From: Rich Elliott <elliotttr@kvfr.org>
Sent: Thursday, August 08, 2013 7:01 PM
To: Jeff Watson
Cc: Joe Seemiller; John Sinclair
Subject: RE: Kittitas County Notice of Public Hearing RZ-13-00001 and SP-13-00003

KVFR feedback –

[RZ-13-00001 and SP-13-00003 Zentz](#)

**ZENTZ SHORT PLAT**  
**KITTITAS COUNTY SHORT PLAT NO. SP-13-**  
 A PORTION OF THE NW 1/4 OF SECTION 20, TOWNSHIP 18 NORTH, RANGE 18 EAST, W.M.,  
 KITTITAS COUNTY, WASHINGTON

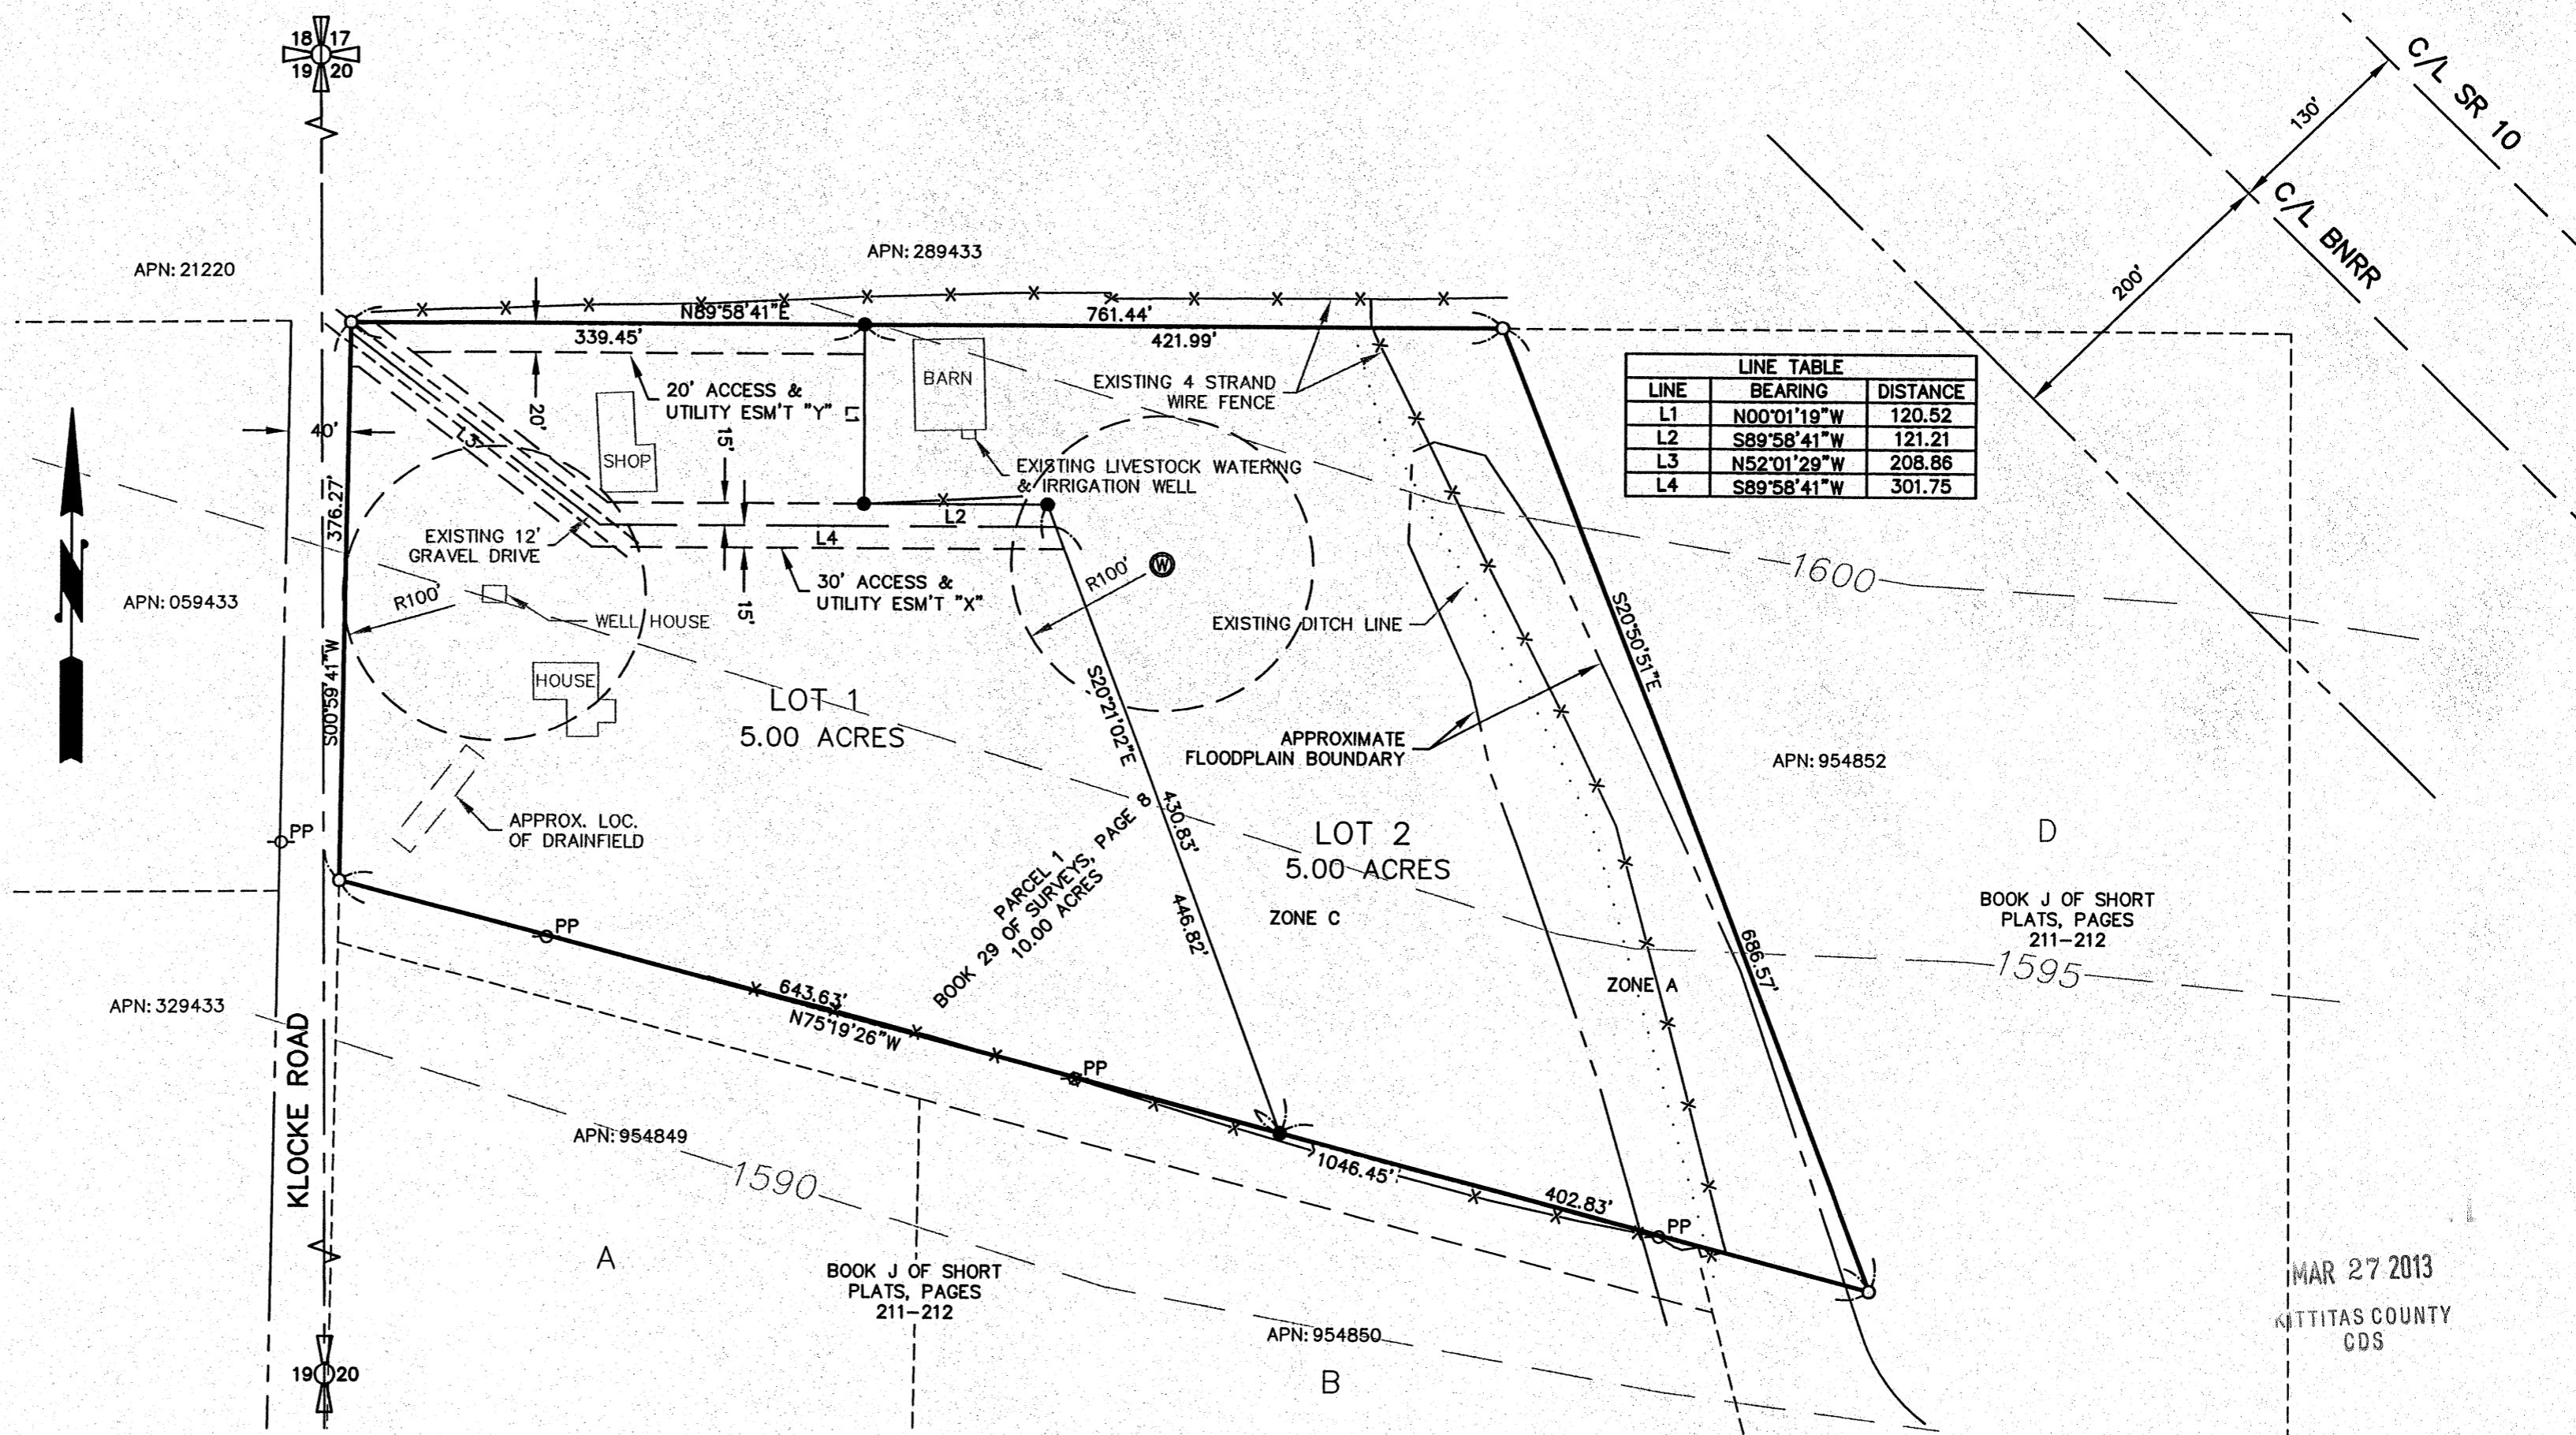
1. Any future development will need to provide access that complies with Appendix D of the applicable International Fire Code.
2. Addressing will need to be easily seen from both directions of travel on Klocke Road.
3. Water supply will need to be addressed in compliance with the Wildland Urban Interface (WUI) code if adopted at time of development.
4. Structures will need to comply with applicable provisions of the WUI code if adopted at the time of development.
